State of Washington
DEPARTMENT OF FISH AND WILDLIFE

RE: WDFW Comments Merten AU-25-00003

Thank you for the opportunity to provide comments for the proposed project to classify the existing manufactured home as an accessory dwelling unit (ADU) and eventually build a new single-family residence on parcel #239433. The Washington Department of Fish and Wildlife (WDFW) is familiar with the project area and nearby critical areas. WDFW provides the following comments for your consideration prior to approval of this project or the approval of a new single-family residence on this parcel.

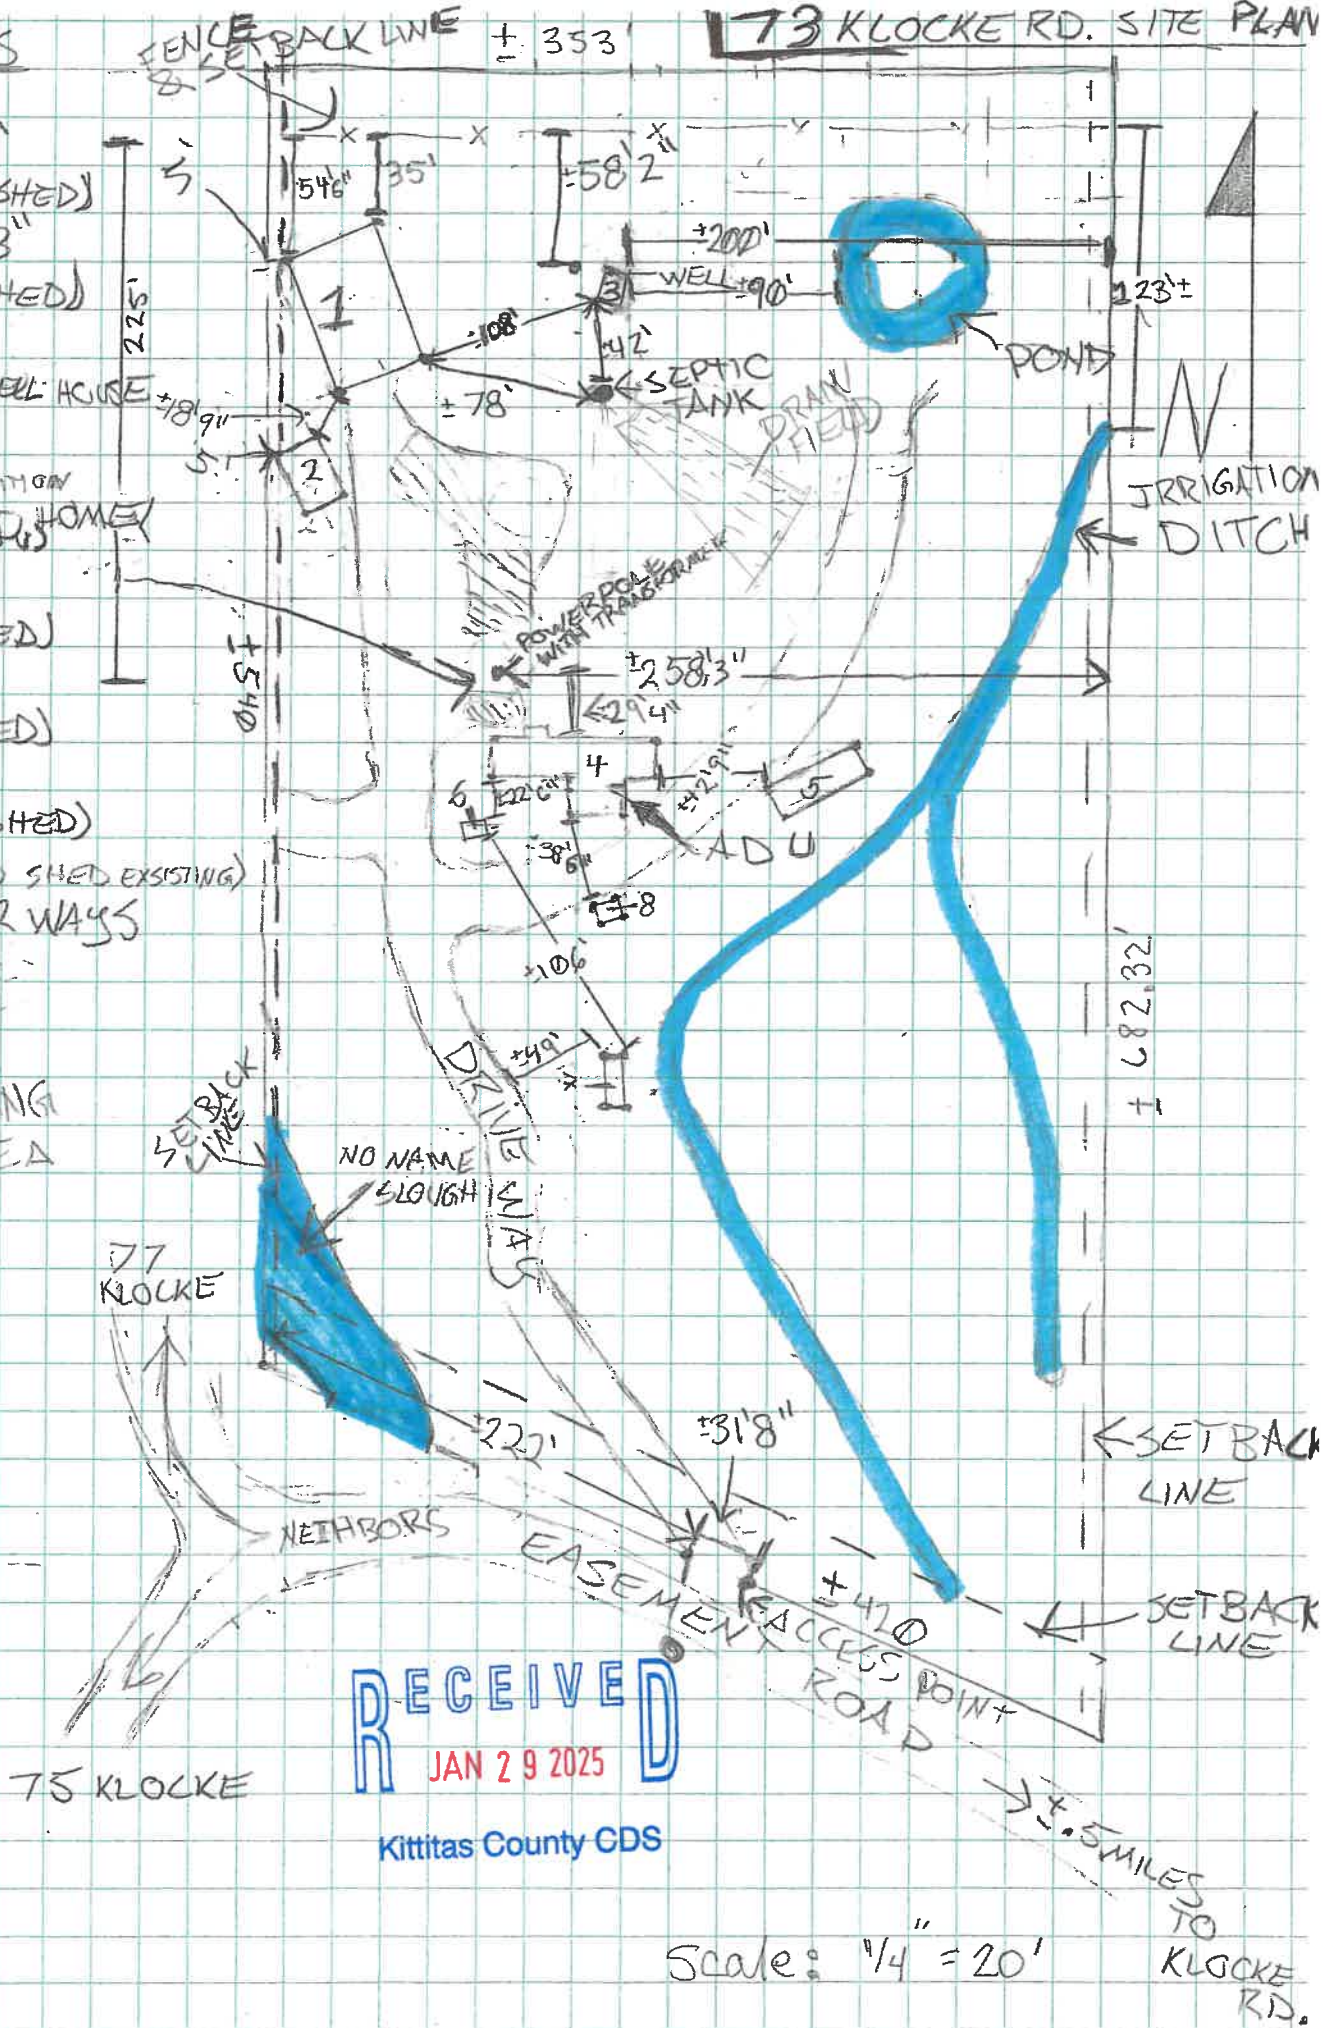
The entirety of the parcel is within the regulatory floodplain as defined by FEMA and Kittitas County. The site plan available for review shows a "No Name Slough" near the southwest corner of the parcel. This watercourse is a modified historic channel of the Yakima River and serves as the fish bypass return path for any fish entrained from the Yakima River into the Cascade Irrigation District's canal. This channel flows into a watercourse referred to as the Holmes Side Channel, near the Yakama Nation's Sampson Coho Facility, before entering the Yakima River. This channel is fish bearing throughout and has had substantial beaver activity; warranting full protection of the Type F channel and the associated Riparian Management Zone prior to approval of the project.

The site plan also shows existing irrigation ditches along the eastern portion of the parcel. The site plan shows the termination points for these ditches, but it's unclear what watercourse these channels may terminate into. WDFW would like to better understand the surface and ground water interactions associated with these channels to determine if they are wholly artificial or if they are modified natural floodplain features that warrant critical area protections. WDFW requests a site visit with the applicant and Kittitas County to better understand these water courses and what impact the proposed project may or may not have on Fish and Wildlife Habitat Conservation Areas.

WDFW recommends that a full critical areas report be completed and that we have the opportunity to review the report prior to approval of this project or the approval of a new single-family residence and the associated septic tank to ensure the proposed building site will be consistent with Kittitas County's Critical Areas Ordinance and there will be no need for variances or reasonable use exemptions for the additional proposed developments on this property. WDFW looks forward to working with the applicants and County staff to avoid impacts to critical areas
